El Paso County Master Plan - Draft Plan Questionnaire

This questionnaire is for you to provide feedback about the draft *Your El Paso Master Plan*. After review of the draft Plan and StoryMap, please identify any changes you would make to the document. For each change, please be sure to include the specific page number from the draft Plan. This will help us connect your comment to the correct section.

**Page 43 – Military
Placetype Image**

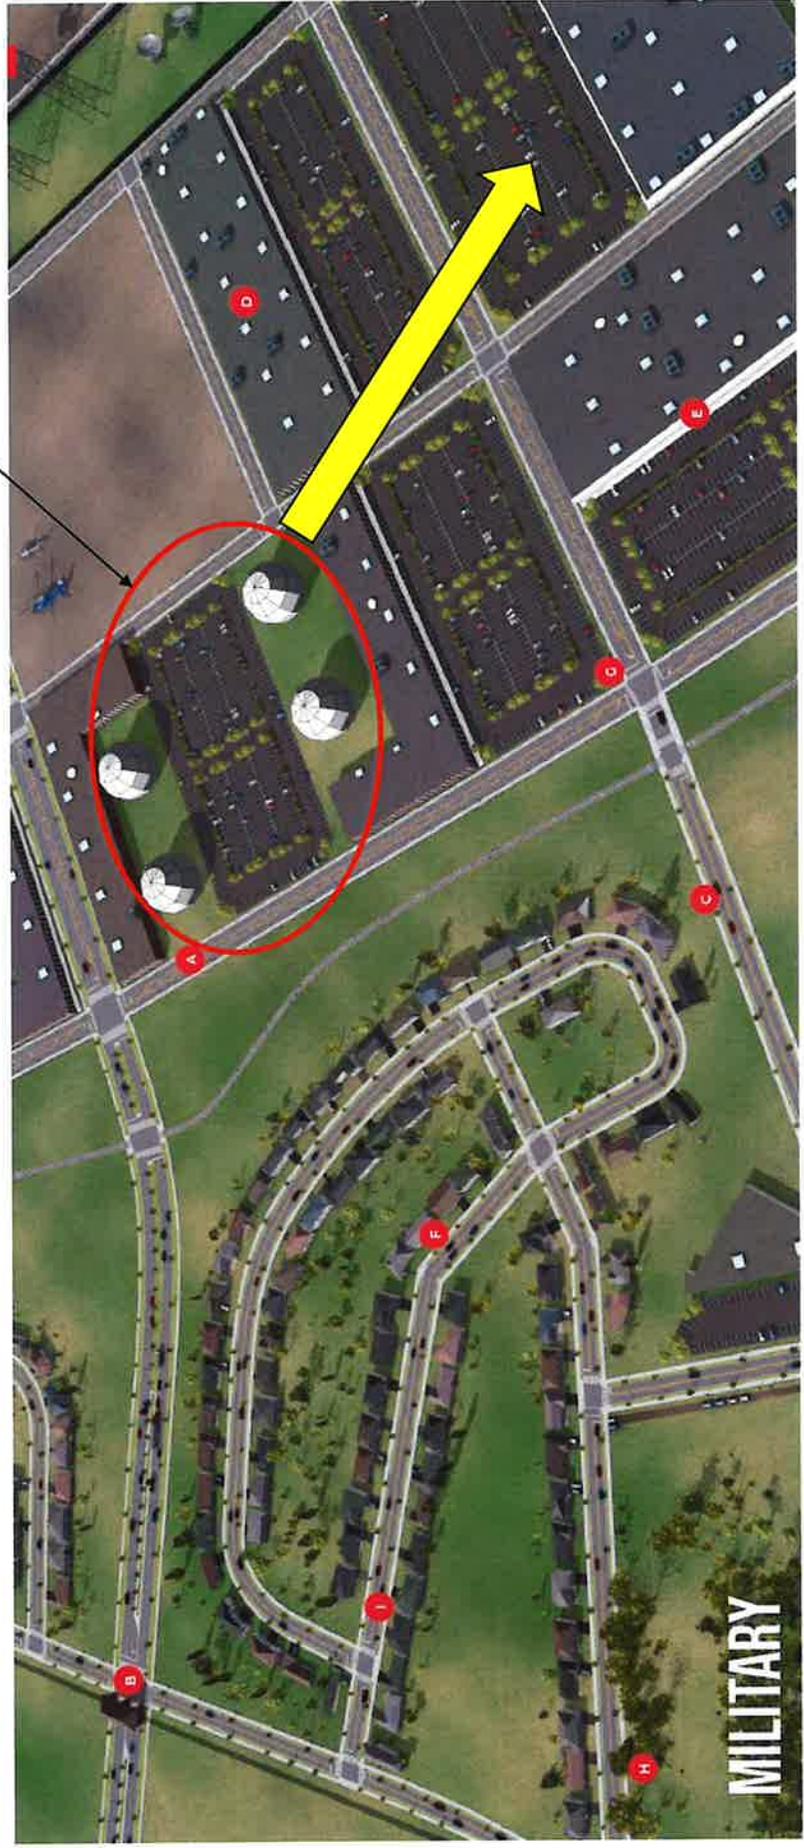
Pg 43, Image: Recommend moving the radomes further away from housing. Placetype Characteristics, Bullet D: Sidewalks and pathways provide a network to connect facilities.

**Page 49 – Housing and
Communities
Framework Map**

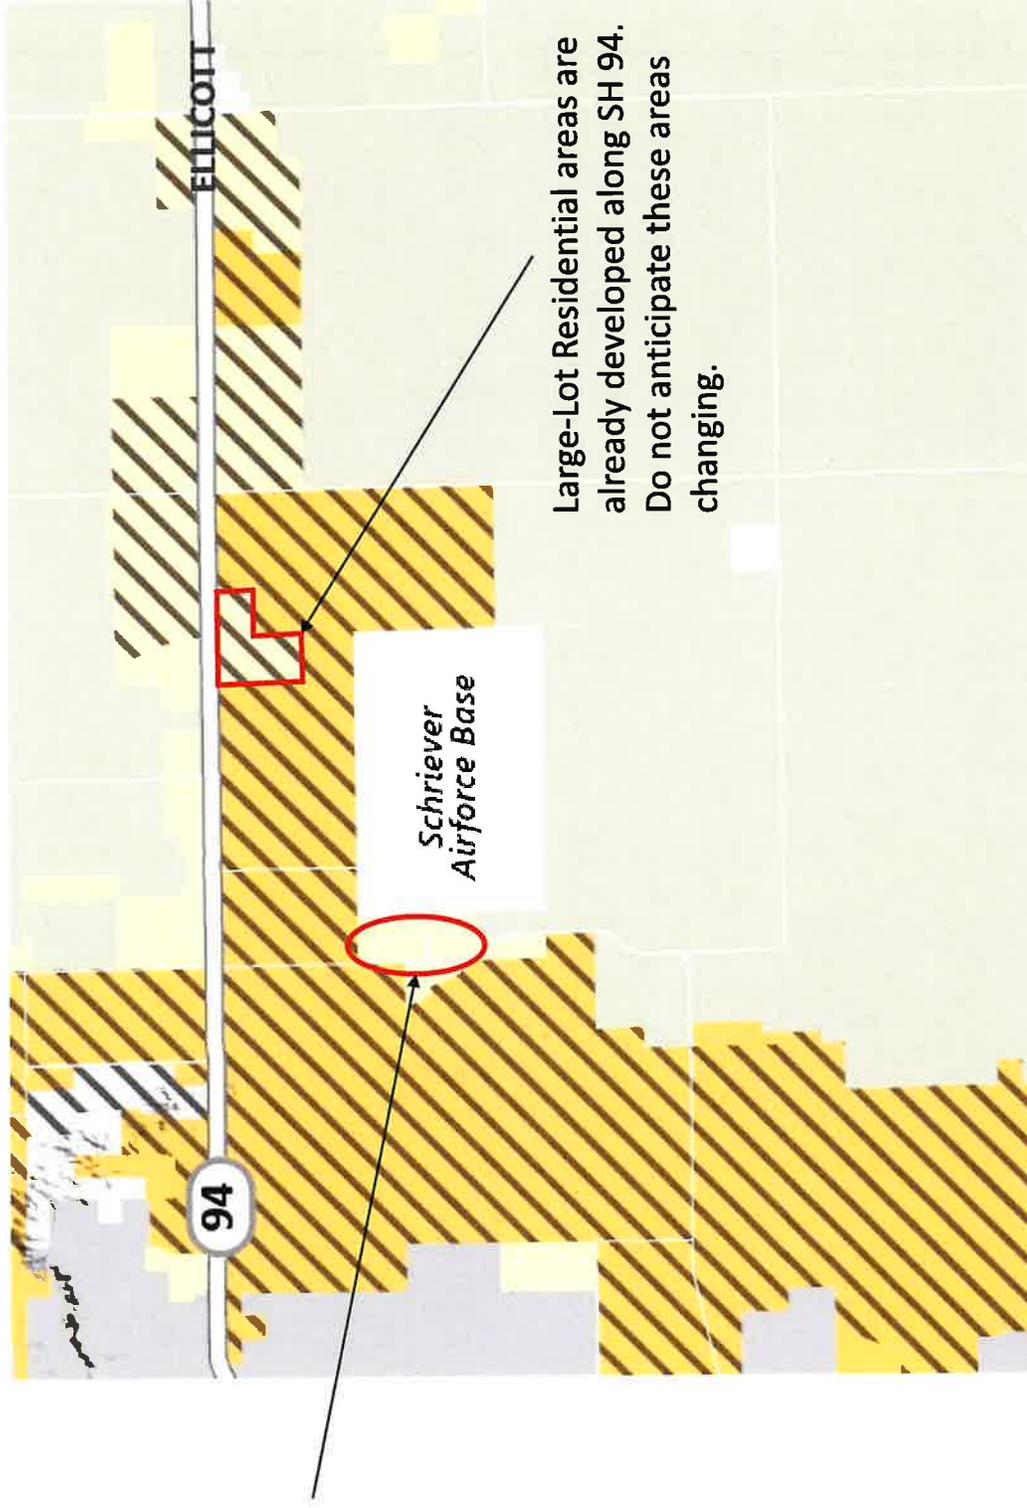
Pg 49, Map: Large-Lot Residential enclave NE of Schriever AFB shouldn't be considered a priority area since it is already developed. Also areas west of Schriever AFB to Curtis Road are predominantly Rural.
